Application for a non-material amendment following a grant of planning permission.

<input type="text" value="Erection of rear extension (single Storey) and installation of solar heating system to the roof following removal of existing greenhouse"/>	
Reference number:	<input type="text" value="CA/21/00785"/>
Date of decision	<input type="text" value="22/06/2021"/>

the applicant now wishes to finish the extension in white render rather than matching red brick. They fee it will be too much red brick

Rear extension and re-modeling works to bungalow	
Beech Hedge Hardres Court Road, CT4 5NU	
Proposed South & East Elevations	
Drawing Number: CB-006 REV 01	
Scale 1:100 @ A3	Drawn By: Chris Brian CB Planning 07810 432 681
Date: 23-09-21

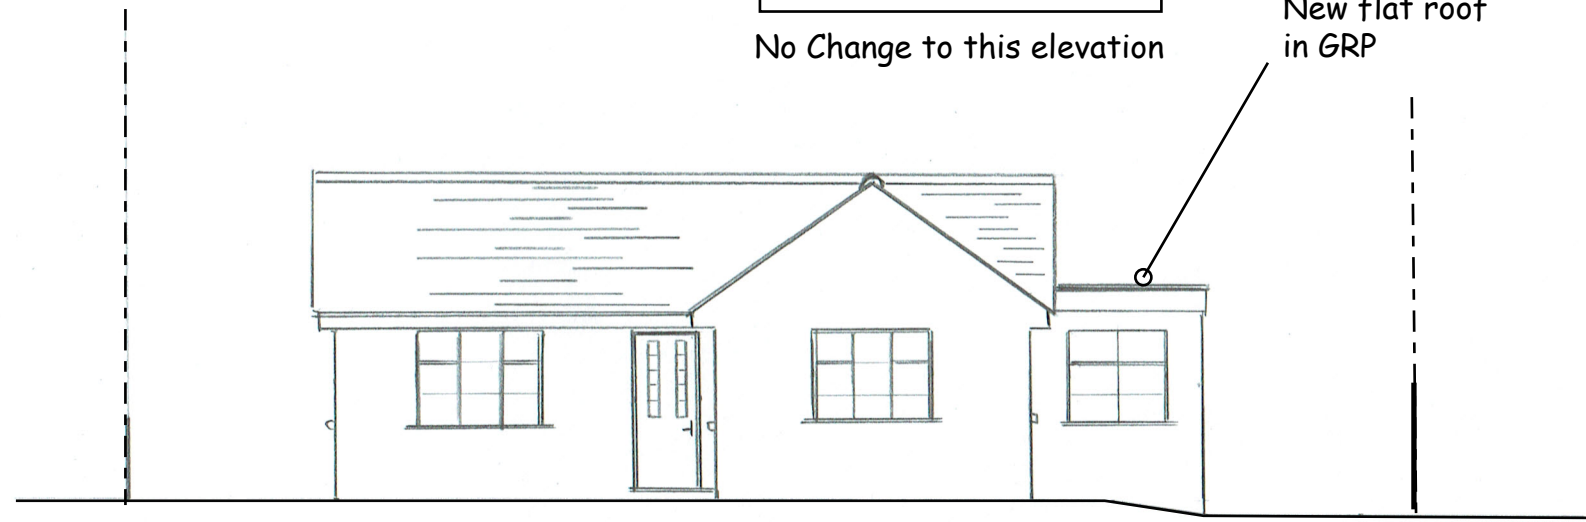
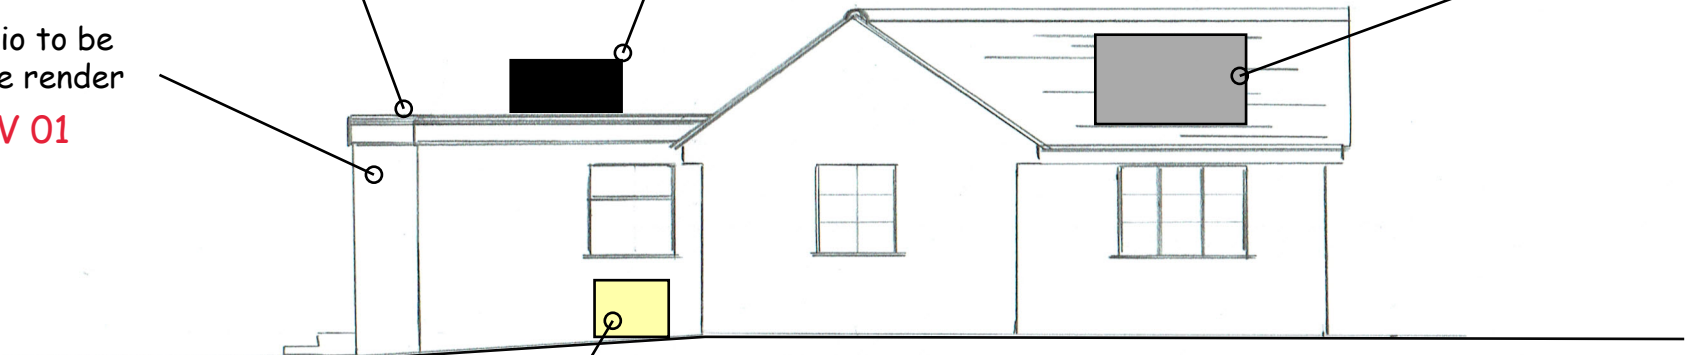
CB-006
CB-007

CB-006 - REV 01
CB-007 - REV 01
